**KIRKLEES METROPOLITAN COUNCIL
INVESTMENT & REGENERATION SERVICE**

DELEGATED DECISION TO DETERMINE PLANNING APPLICATIONS

Reference No:	2024/62/91616/E
Site Address:	2, Kensington Way, Gomersal, BD19 4FB
Description:	Erection of single storey rear extension with front porch
Recommending Officer:	Jennifer Booth

DECISION - REFUSED

PROPOSED ROOF PLAN

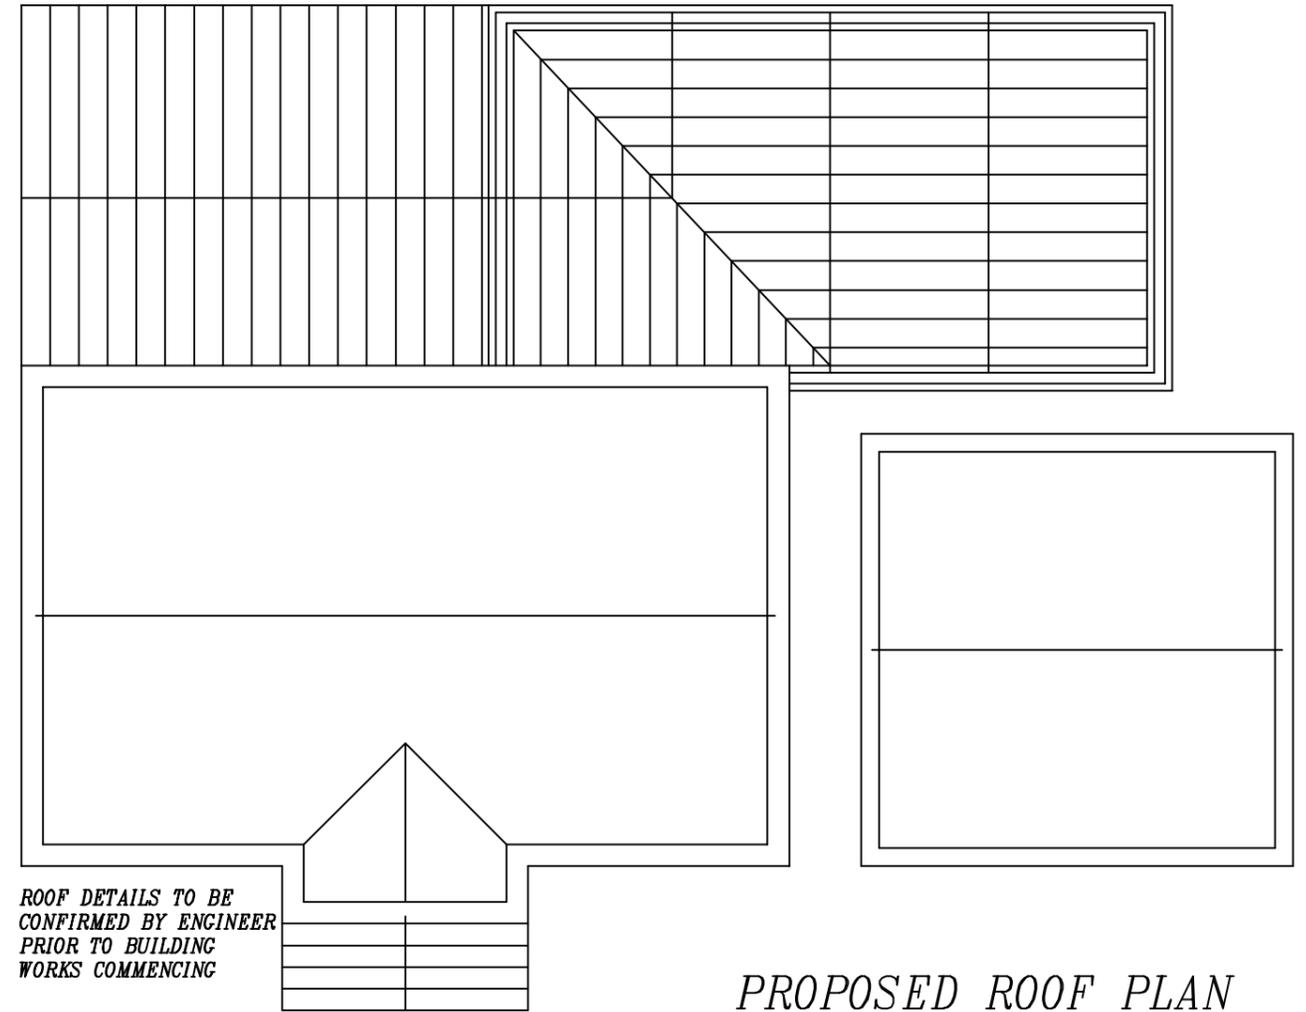
It is noted that the size of the extension has been reduced since the previous refusal, the roof design has also been simplified and that the link from the house into the garage has been removed. However, the scale of the extension together with the design of the pitched roof and canopy would form a poor relationship with the main house in a position of prominence. Although it is noted that the materials include artificial stone for the walling with tiles for the roof covering, which would match the main house, the overall design and scale is considered to still result in the formation of an incongruous feature in a position of prominence from multiple viewing points in the area and therefore is considered to be unacceptable in terms of visual amenity.

PLANNING/BUILD REGS | DRAWING NUMBER: 23/2960/G4

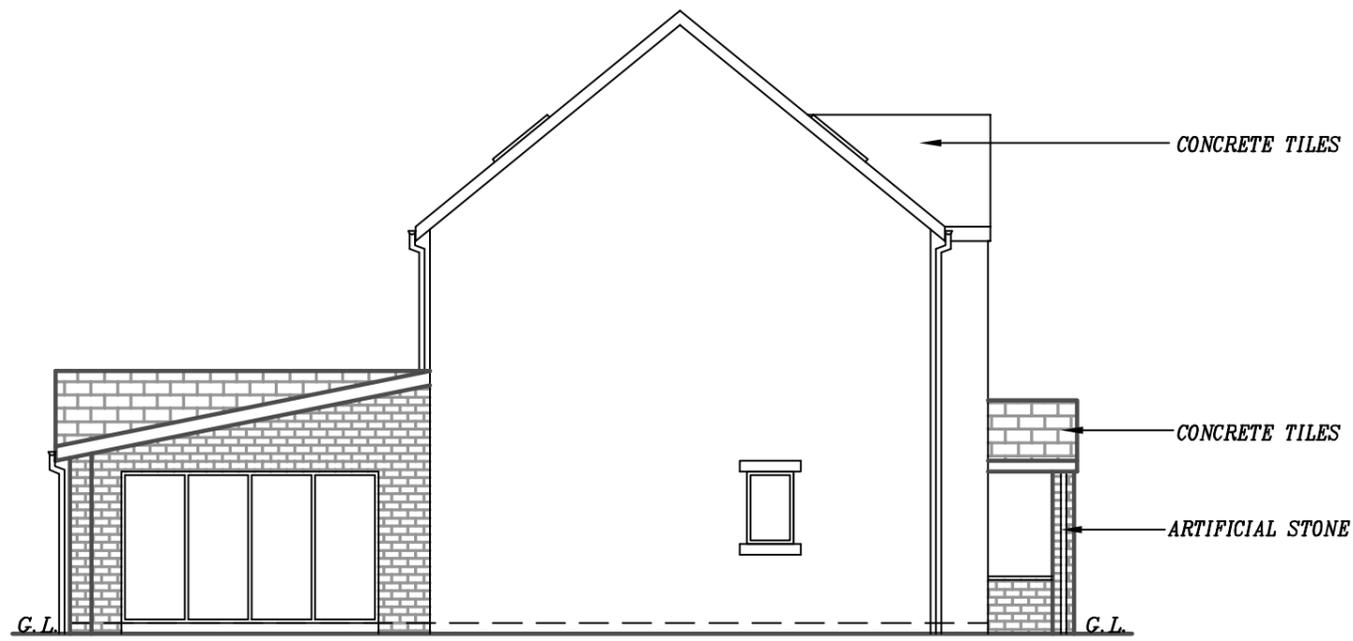
Having taken the above into account, the proposals have not overcome the previous reason for refusal and would result in unacceptable harm in terms of visual amenity as the roof design and overall scale, in a position of prominence, would result in the formation of an incongruous feature which would be out of the character with the host property and the wider street scene. The proposals therefore fail to comply with Policy LP24 of the Kirklees Local Plan (a) in terms of the form, scale and layout, KDP 1 & 2 of the House Extensions & Alterations SPD and the aims of chapter 12 of the National Planning Policy Framework.

1. The proposed side and rear extension, by reason of the overall design and scale would result in unacceptable harm in terms of visual amenity due to the formation of an incongruous feature which would be out of the character with the host property and the wider street scene. To permit the proposals would be contrary to Policy LP24 of the Kirklees Local Plan, KDP 1 & 2 of the House Extensions & Alterations SPD and advice within chapter 12 of the National Planning Policy Framework.
